From: Laura Gibbons [REDACTED]
Sent: 04 May 2021 15:28
To: Anita Gardner <Anita.Gardner@arun.gov.uk>
Cc: Planning.Responses <Planning.Responses@arun.gov.uk>
Subject: Re: FW: FW: Planning Consultation on: CM/11/21/DOC

Application No: CM/11/21/DOC

Site Address: Scyld Horsemere Green Lane Climping BN17 5QZ

Description of Works: Approval of details reserved by condition imposed under CM/21/19/PL relating to conditions 11-surface water drainage scheme, 12-discharge of flows to water courses or for the culverting, diversion, infilling or obstruction of any water course on or adjacent to site & 13-maintenance and management of surface water drainage system.

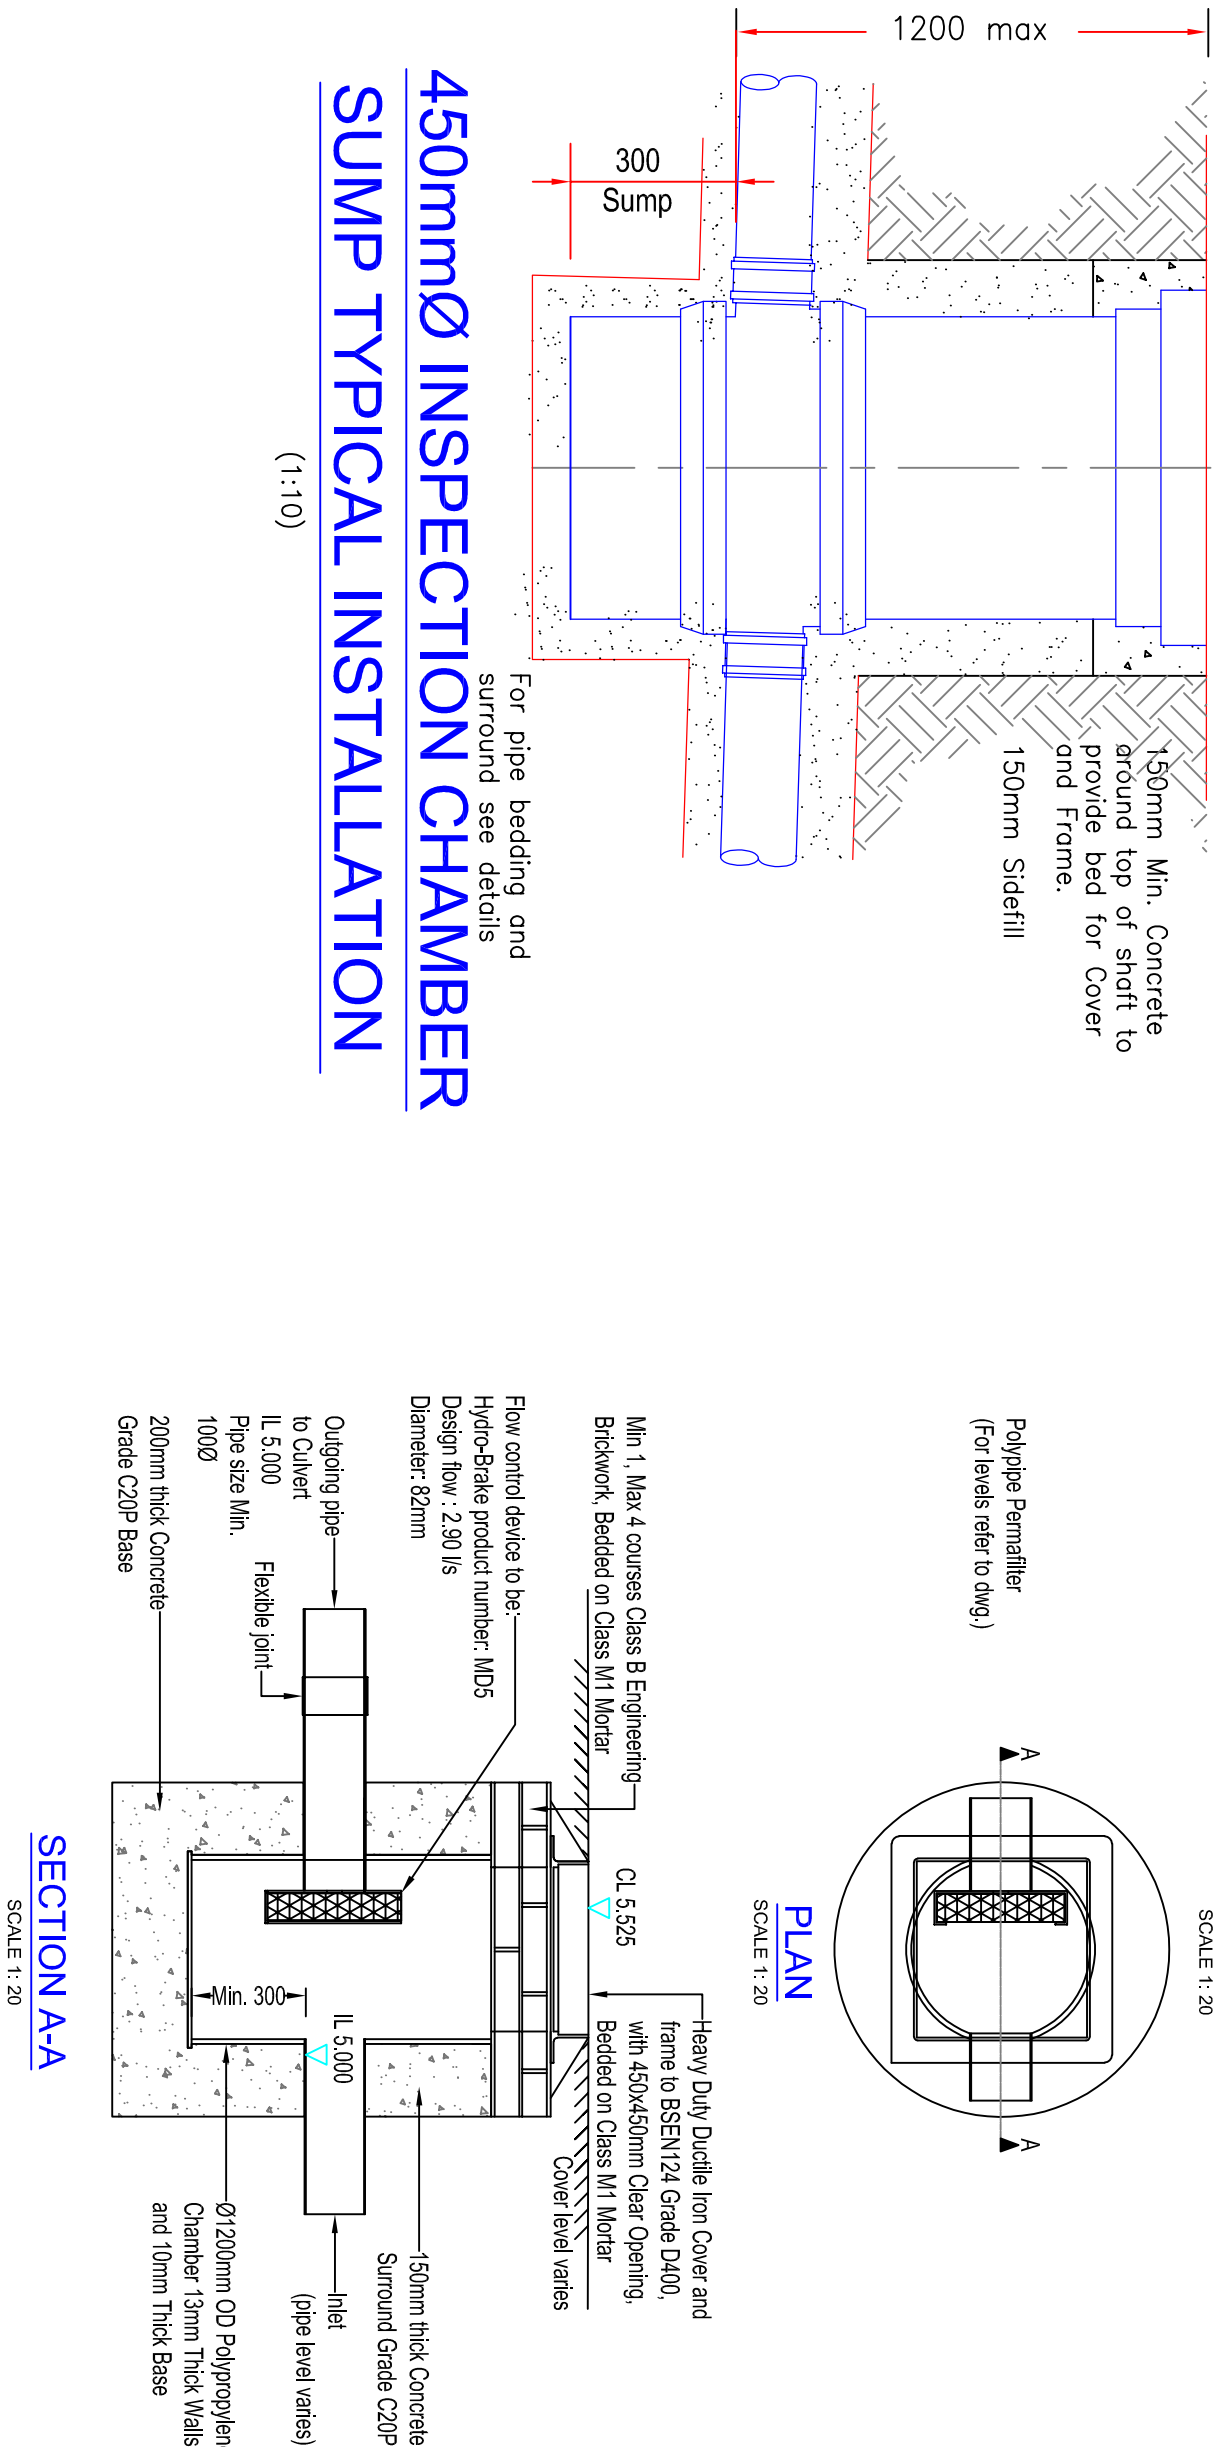
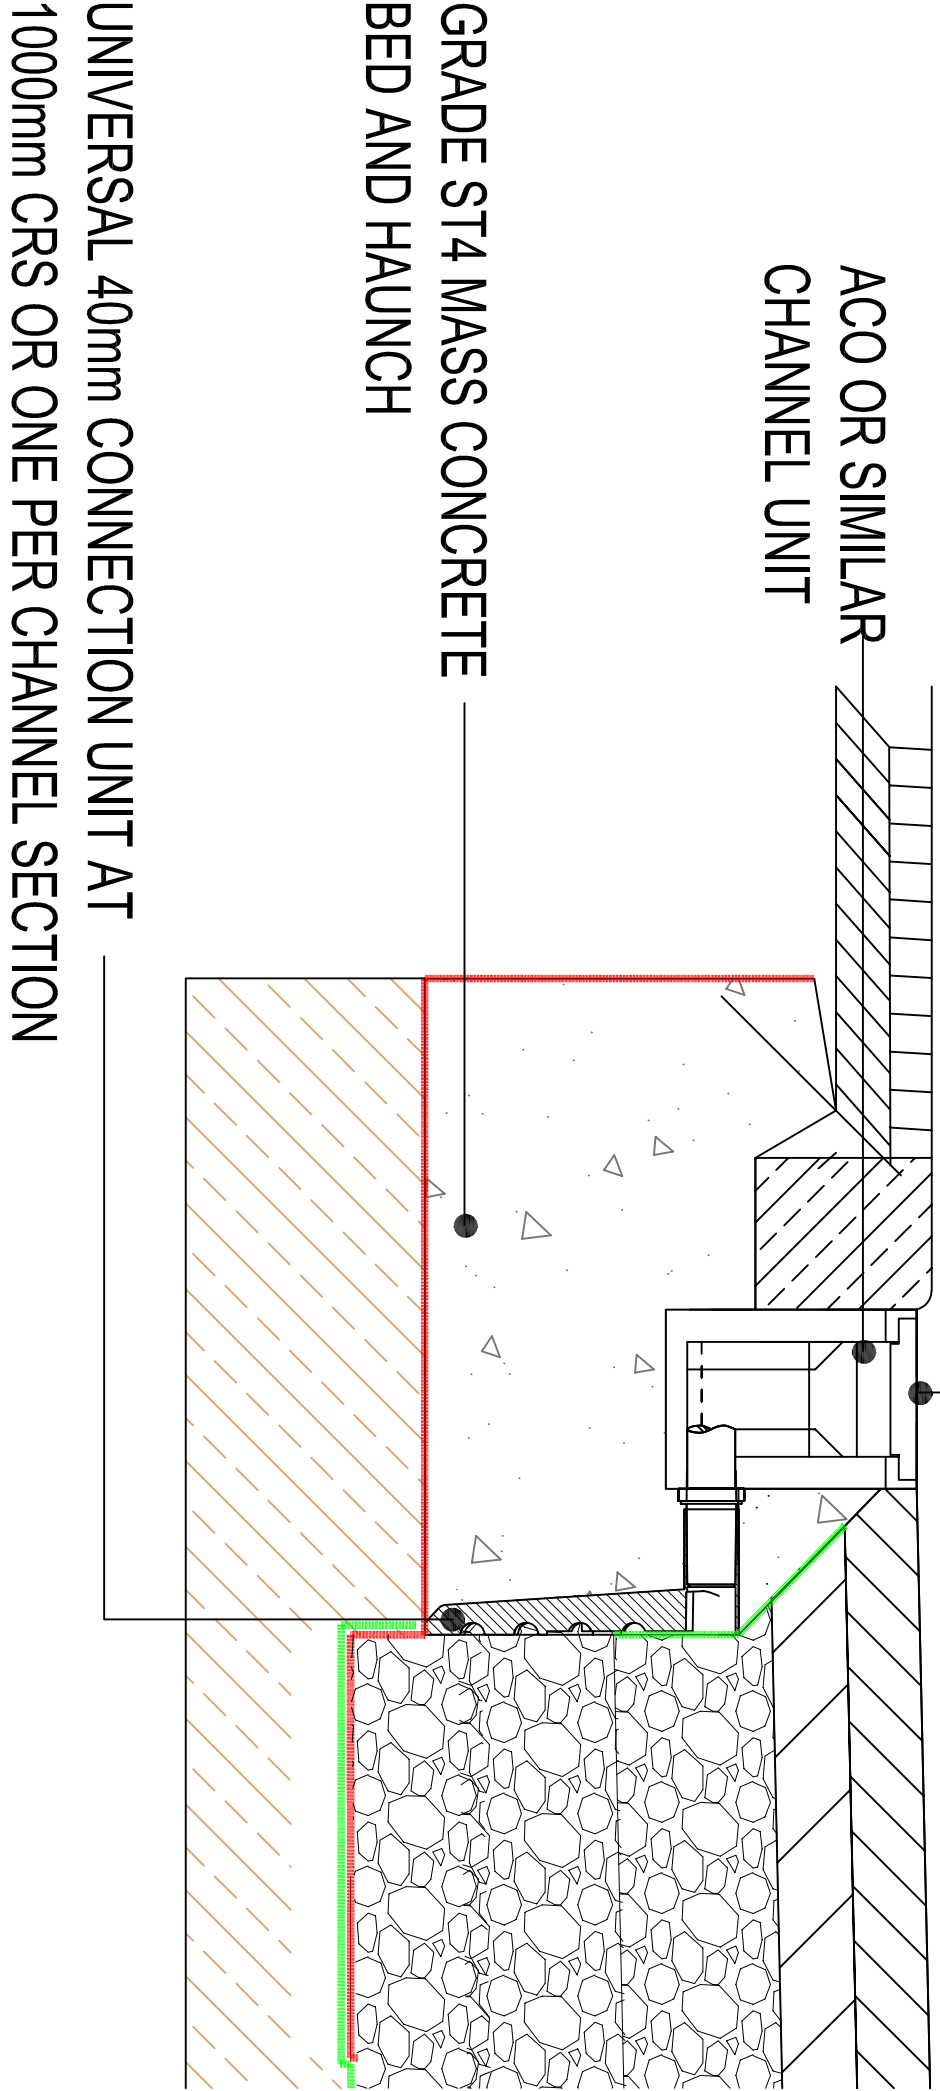
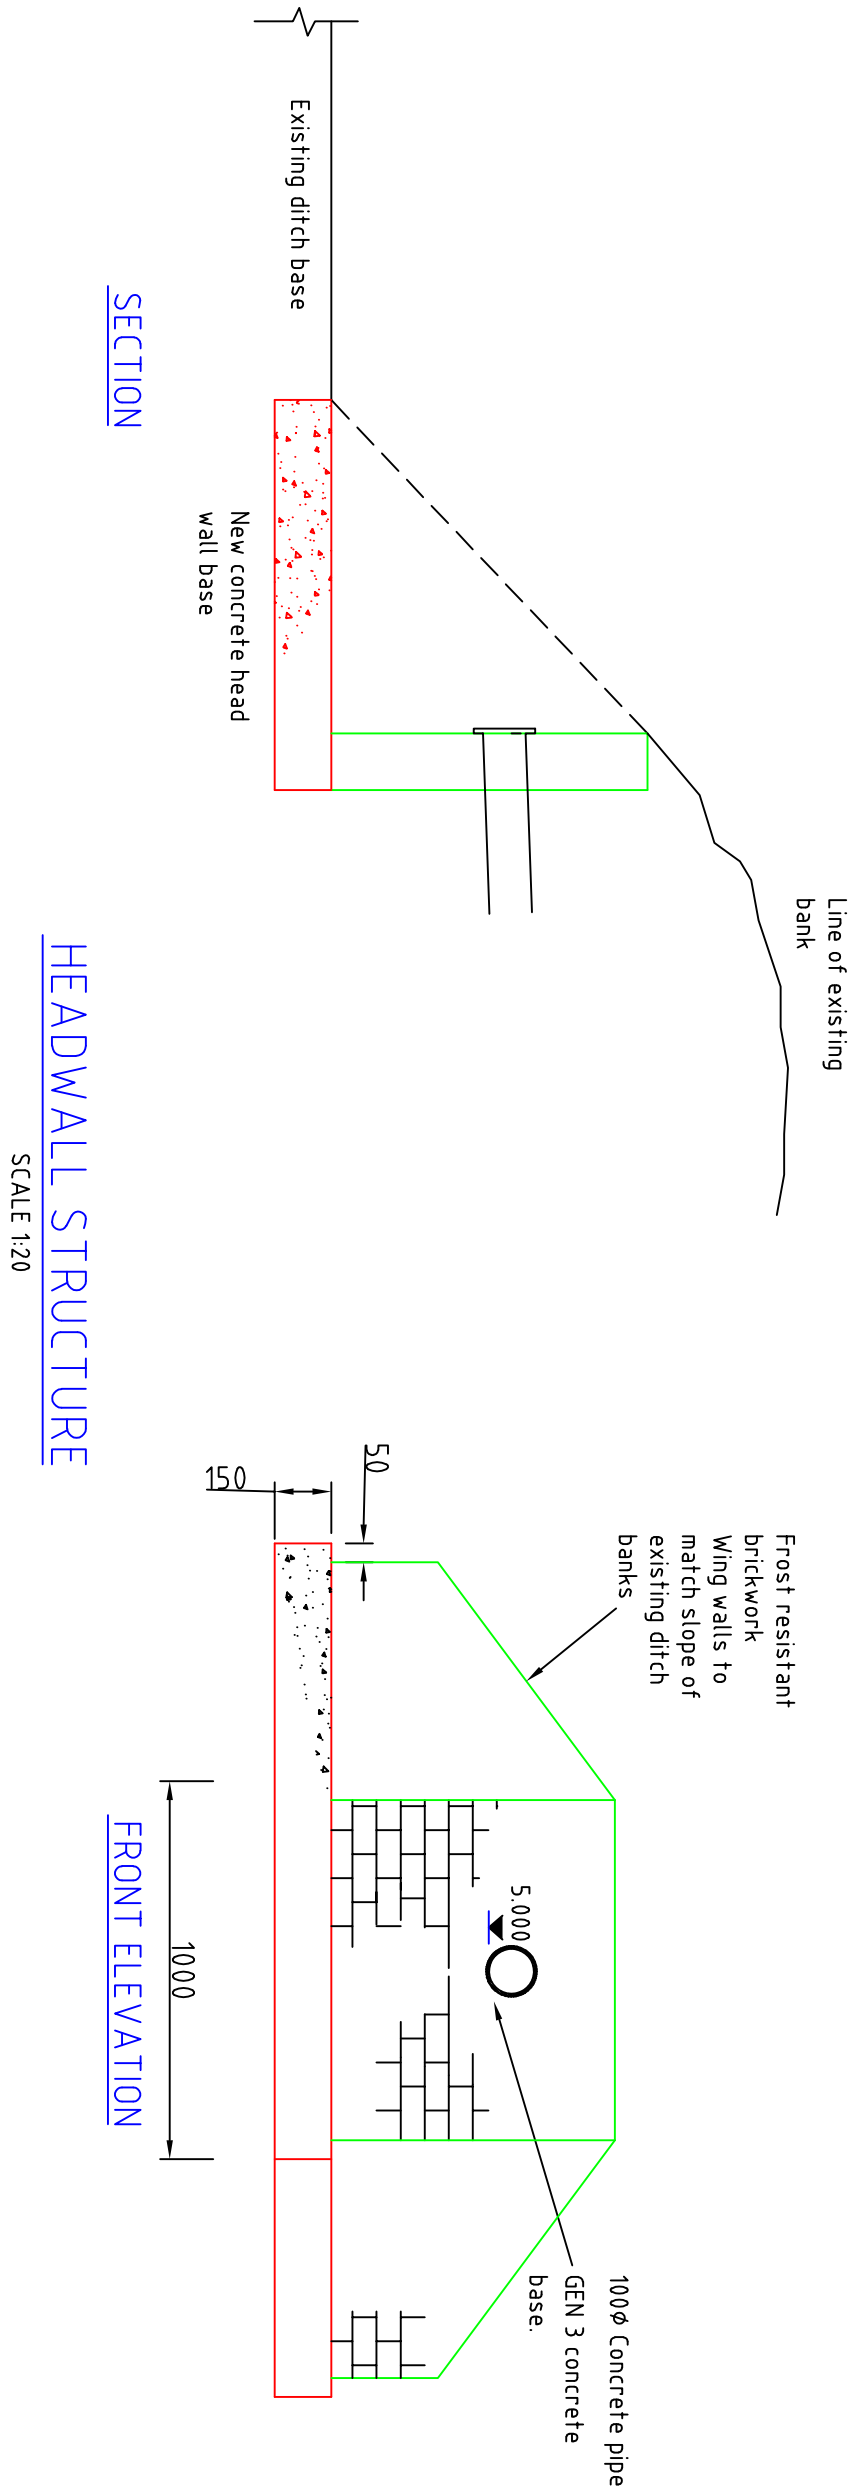
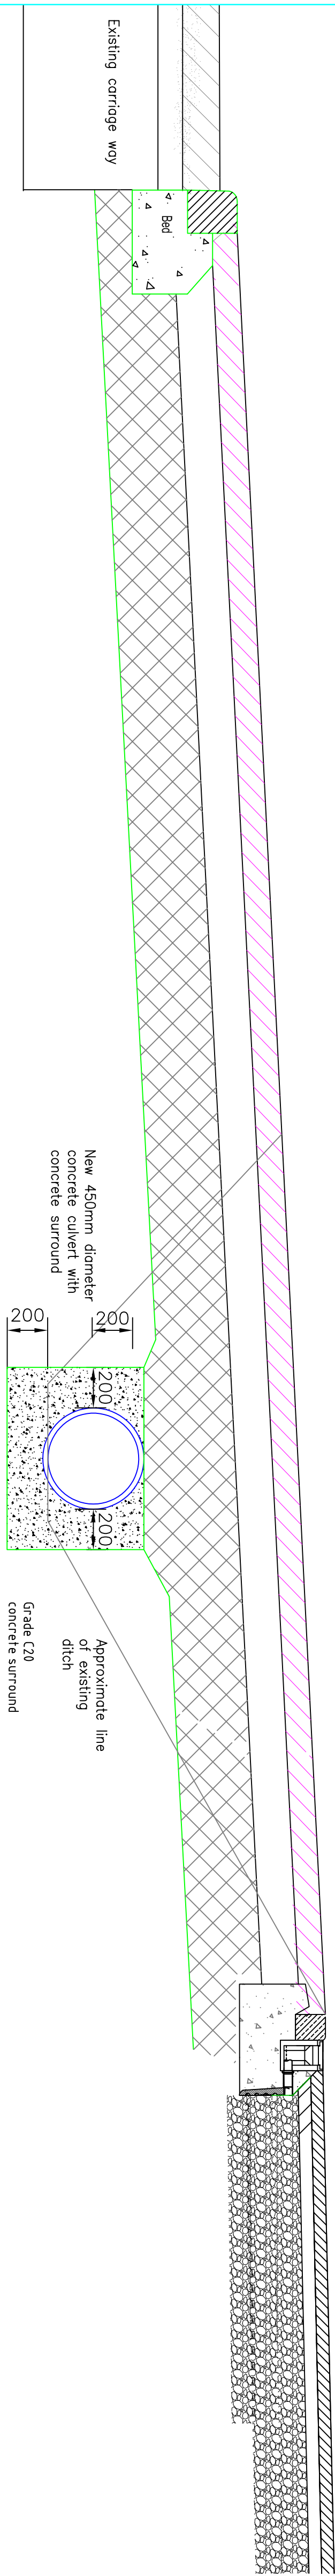
7. Please provide site specific construction detail drawings of the proposed headwall, this should include a plan and full cross section through the ditch. All headwall drawings should indicate existing bed level, and top of bank level. Detail updated. *Two sets of drainage details sheet 2 have been provided, please confirm which version should be reviewed.*

1. Please supply further details of the proposed culvert, i.e. diameter, invert level, and construction details- including headwalls. We have put more information on the drawing on the details drawing. *Two sets of drainage details sheet 2 have been provided, please confirm which version should be reviewed.*
2. It is stated on the plans that the culverting has been agreed, we do not believe this to be the case. Please supply evidence that an application for land drainage consent has been made for both the proposed culverting and outfall headwall. This has been applied for and we are issuing new information and the application is ongoing. *Okay.*

1. No connections are shown to/ from the permeable car park areas. We have now shown a connection into the storm drainage system.
7. Please provide site specific construction detail drawings of the proposed headwall, this should include a plan and full cross section through the ditch. All headwall drawings should indicate existing bed level, and top of bank level. *Detail updated. Two sets of drainage details sheet 2 have been provided, please confirm which version should be reviewed.*

1. Please supply further details of the proposed culvert, i.e. diameter, invert level, and construction details- including headwalls. *We have put more information on the drawing on the details drawing. Two sets of drainage details sheet 2 have been provided, please confirm which version should be reviewed.*
2. It is stated on the plans that the culverting has been agreed, we do not believe this to be the case. Please supply evidence that an application for land drainage consent has been made for both the proposed culverting and outfall headwall. This has been applied for and we are issuing new information and the application is ongoing. *Okay.*
